Householder Proforma

Application Ref: 2022/0217
Address: 10 Francus Royd, Carlton, Barnsley, S71 3FF
Property Description: The detached buff brick dwelling is located in a modern housing development and benefits from a two-storey extension and single storey rearwards projection which forms part of the original dwelling. The dwelling is situated to the east of open green space and is screened by shrubbery which is located along the eastern boundaries of the green space.

Proposed Extension: Erection of first floor extension to rear of dwelling.

First Floor

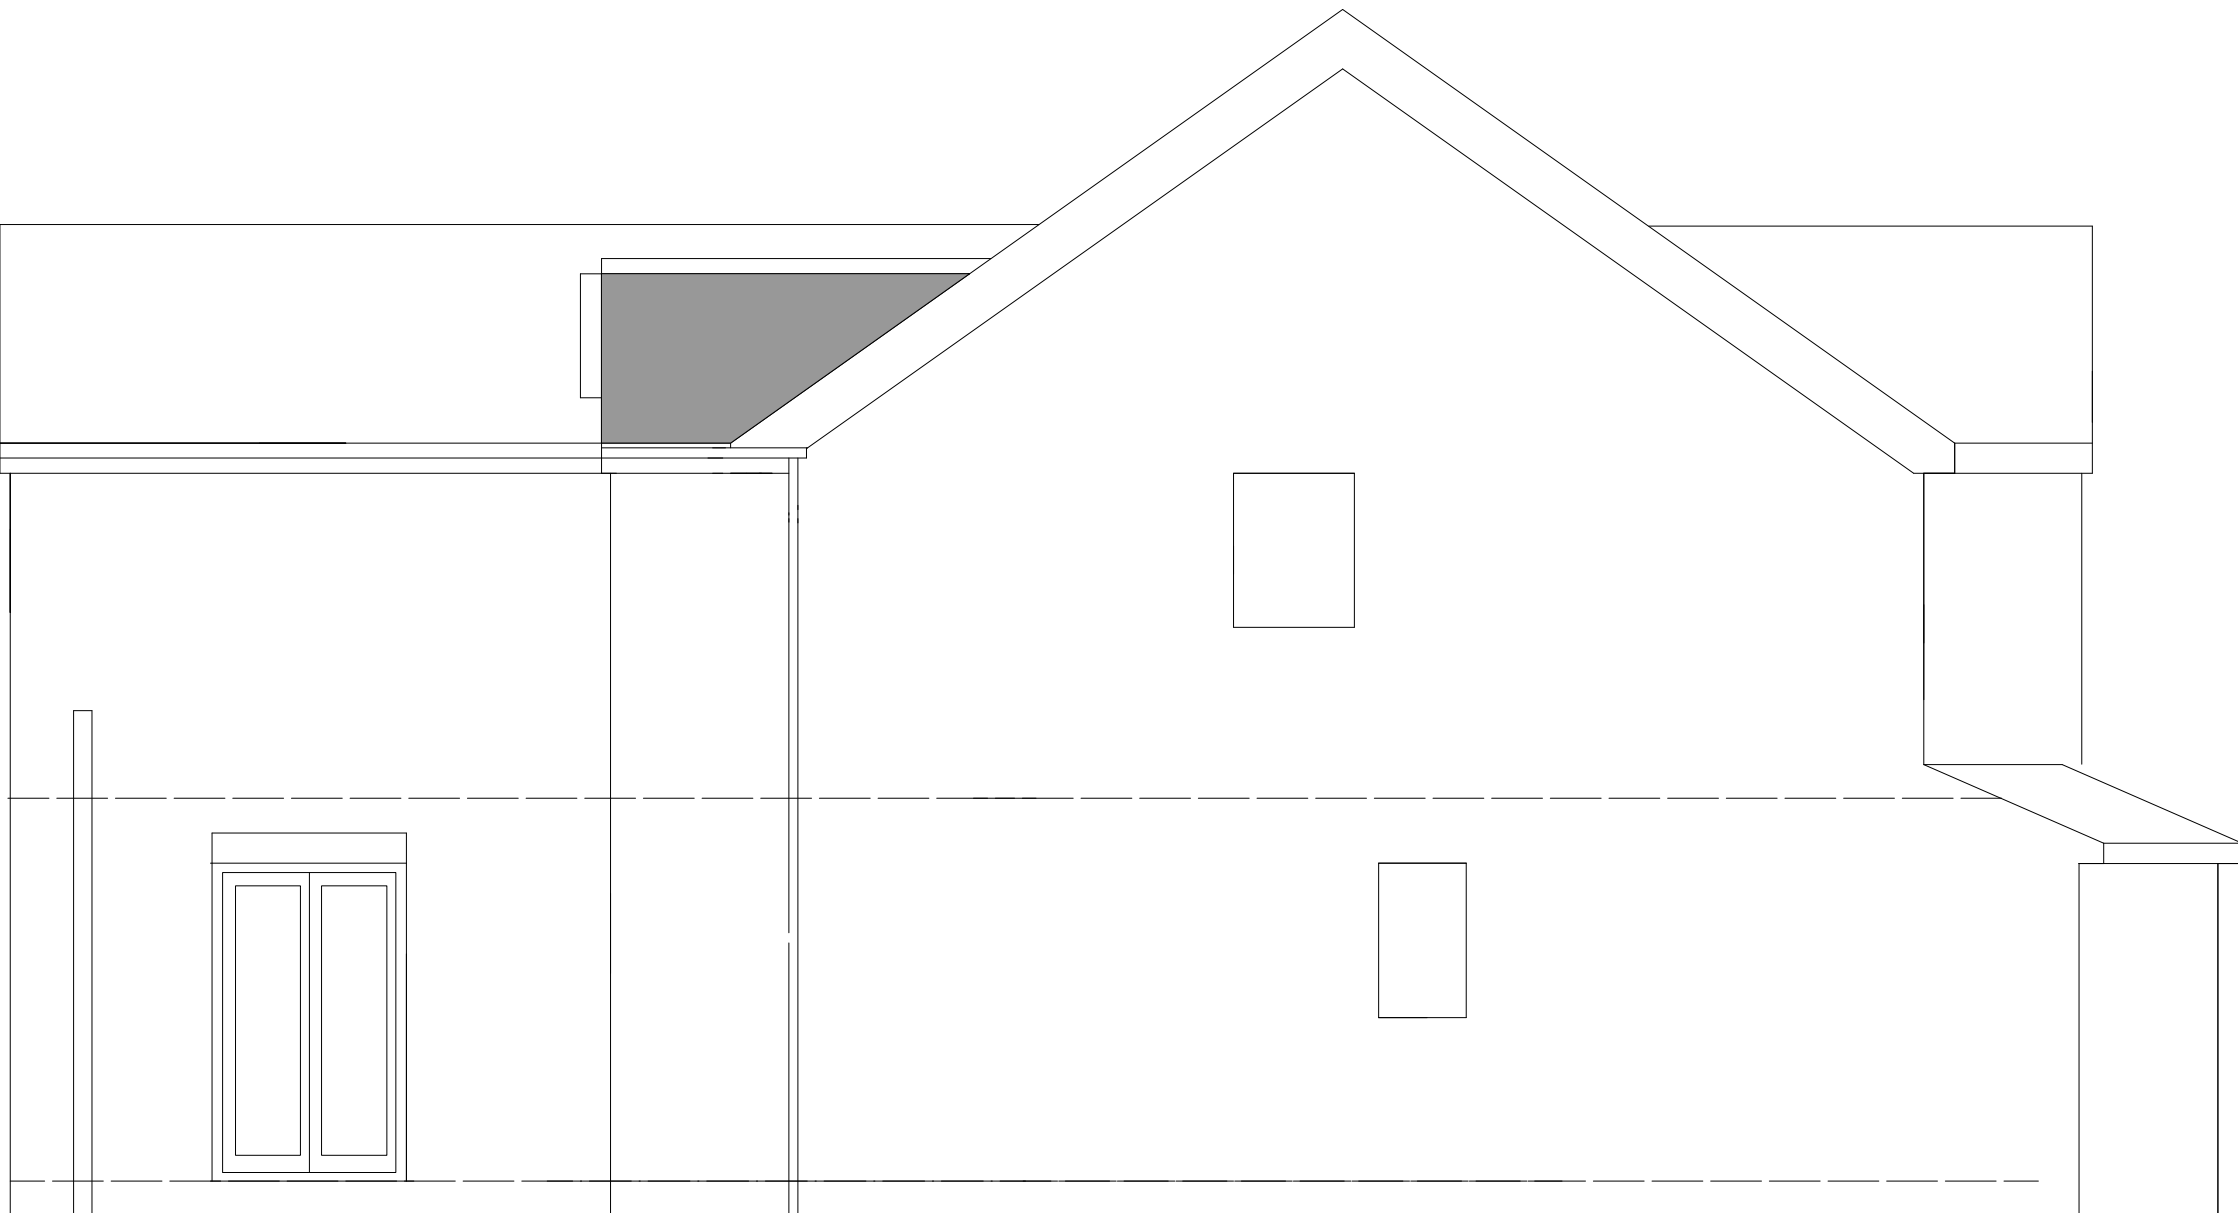
The applicant seeks permission for the erection of a 1.3m first floor extension above an existing single storey projection on the rear elevation of the dwelling. The proposed extension is modest in nature and would not lead to an increase in overshadowing or loss of outlook to an unreasonable level. Whilst the proposed extension would project closer to the rear boundary, it would not project closer than the existing two

storey rear projection, therefore not increasing levels of overlooking to an unreasonable level. It is proposed to be constructed from materials which match the original dwelling along with a roof style and pitch which harmonises and remains subordinate to the main property.

Recommendation: Approve with conditions
